KITTITAS COUNTY

DEPARTMENT OF PUBLIC WORKS

MEMORANDUM

TO: All Staff
FROM: Public Works Plan Review Team
DATE: August 15, 2023
SUBJECT: BL-23-00009 Rarden

BOUNDARY LINE ADJUSTMENT BL-23-00009

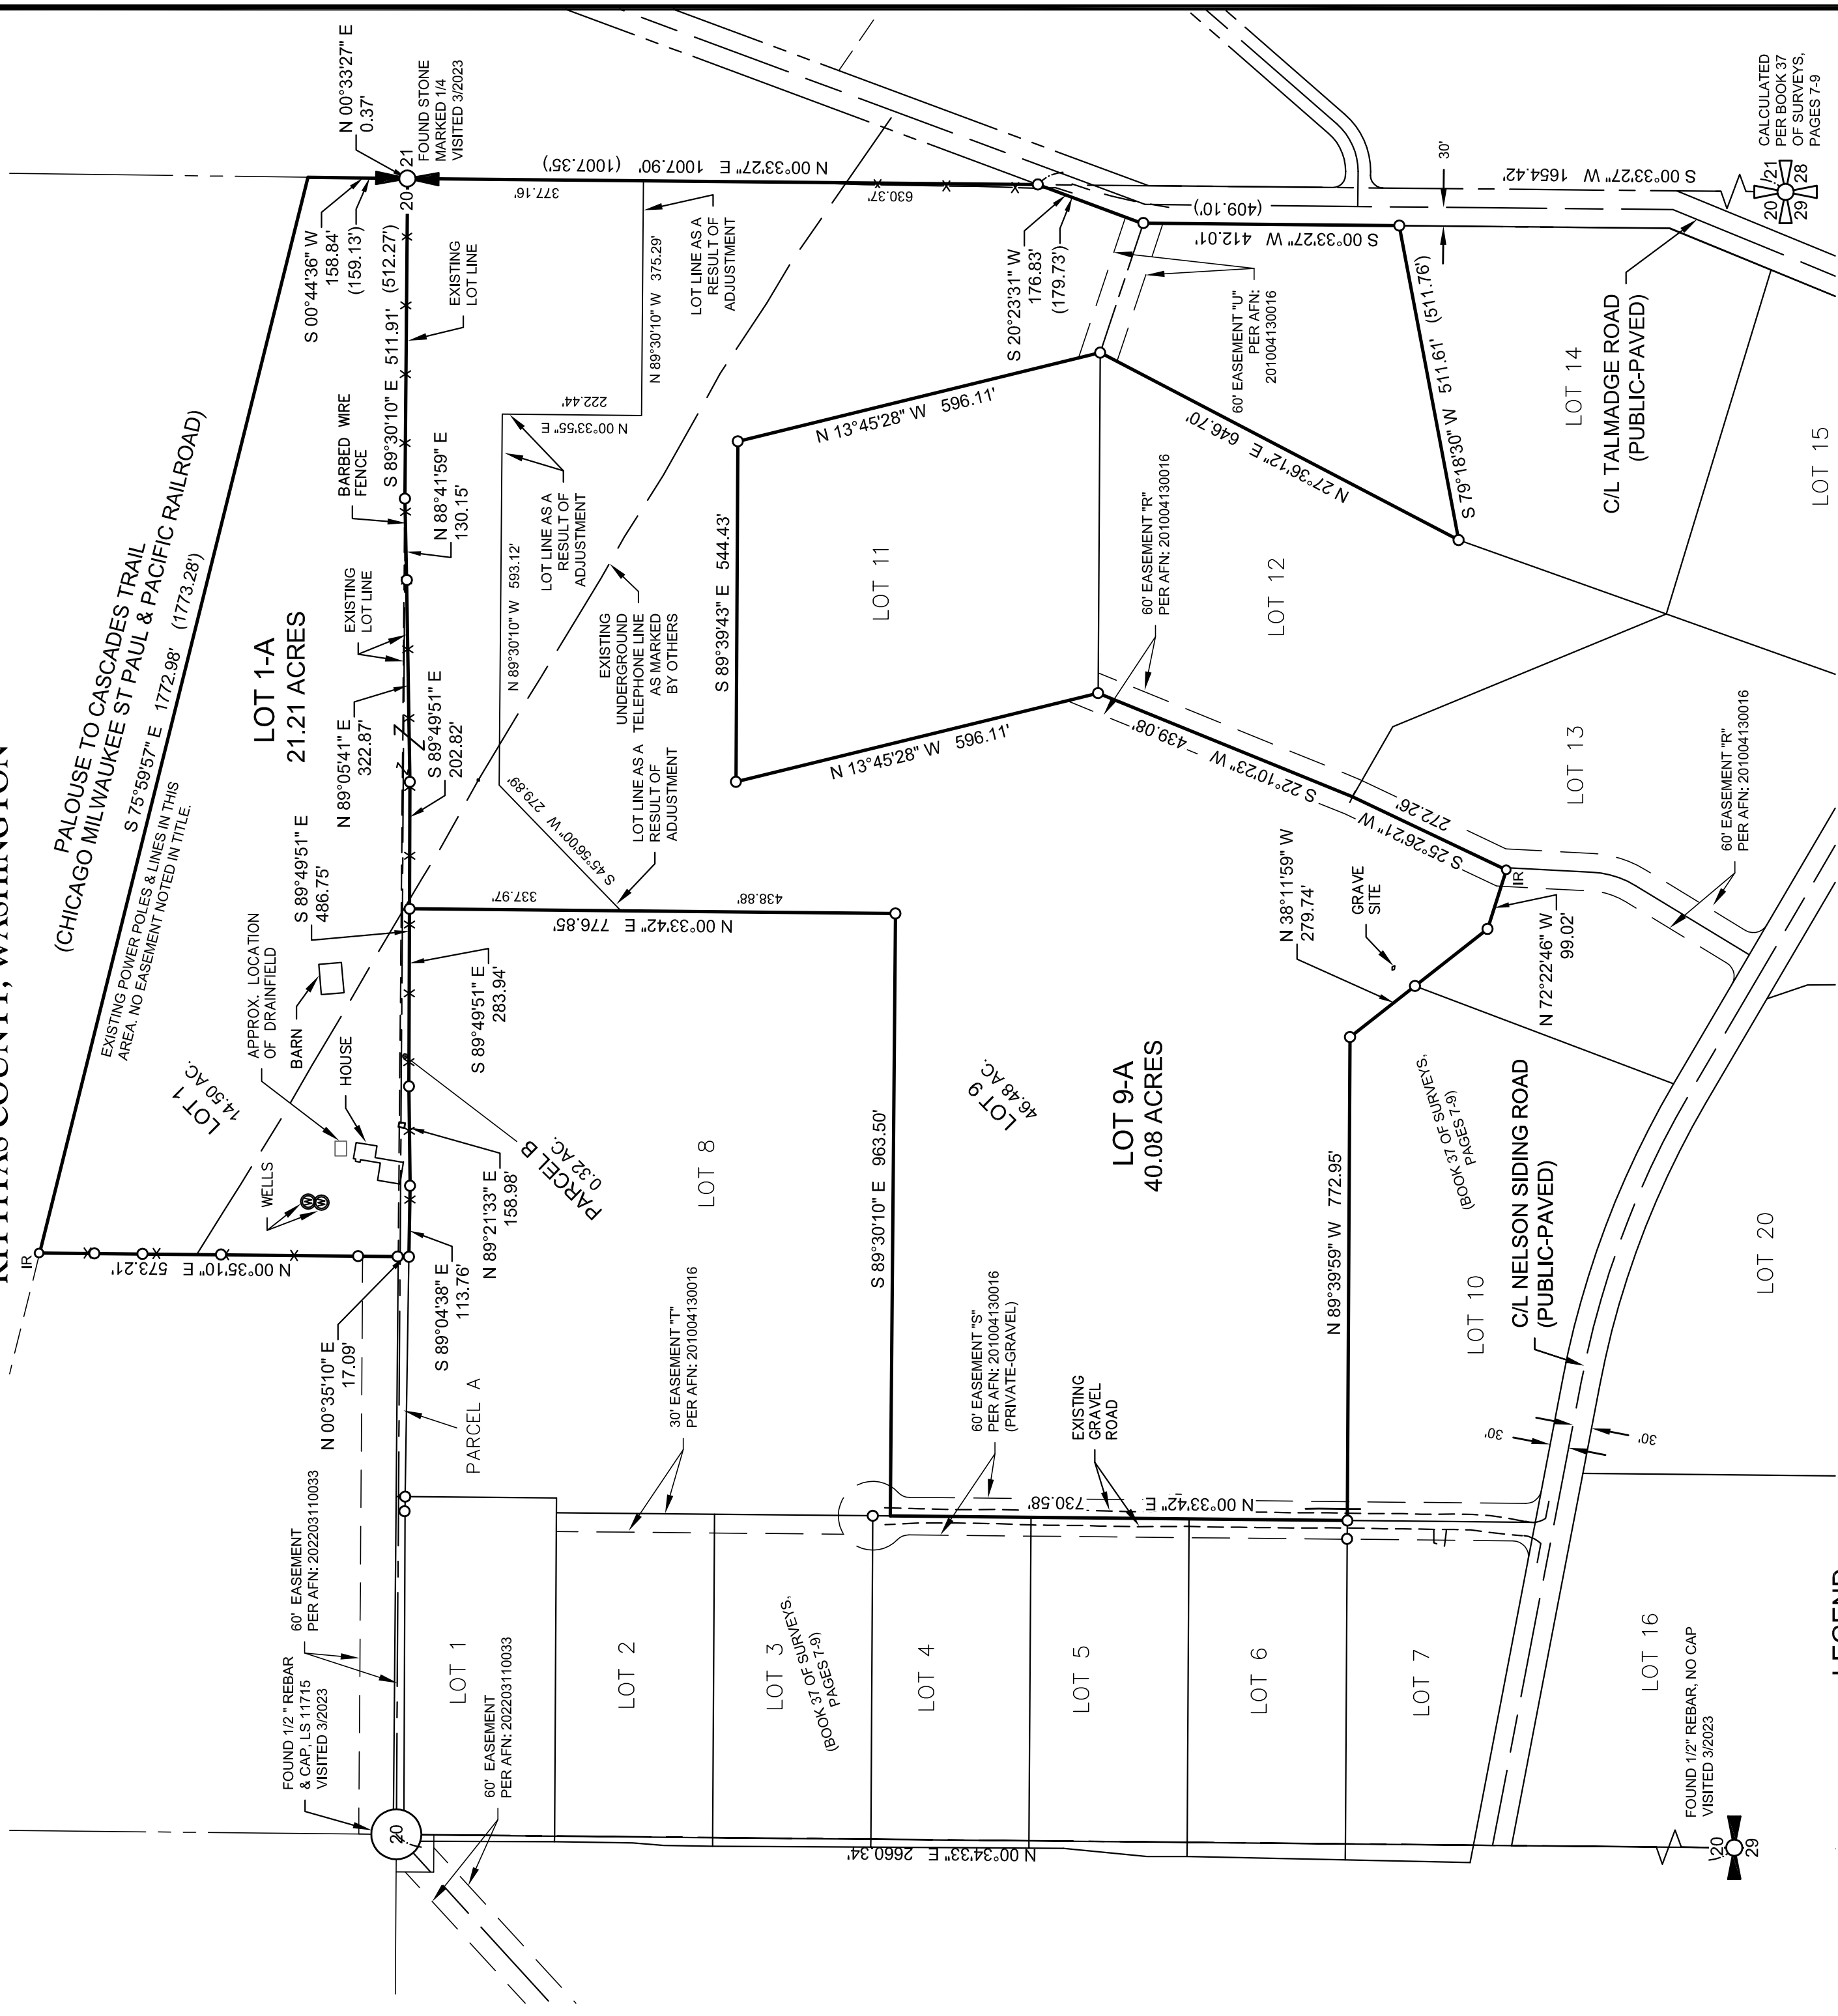
<p>ENGINEERING</p>	<p>No comments (CC).</p>
<p>SURVEY</p>	<p>Provided site plan only, comments reserved for later date when survey is provided for final review. (KH)</p> <p>UPDATE 7/31/2023</p> <ol style="list-style-type: none"> 1. A detail window for the 0.37' line located at the East quarter corner of section would clarify things. 2. The North line of SE1/4 should be shown, in order to tie section corners to the survey. 3. Identify and note discrepancies with various bearings and corner positions (per discussion with Mr. Pierce).
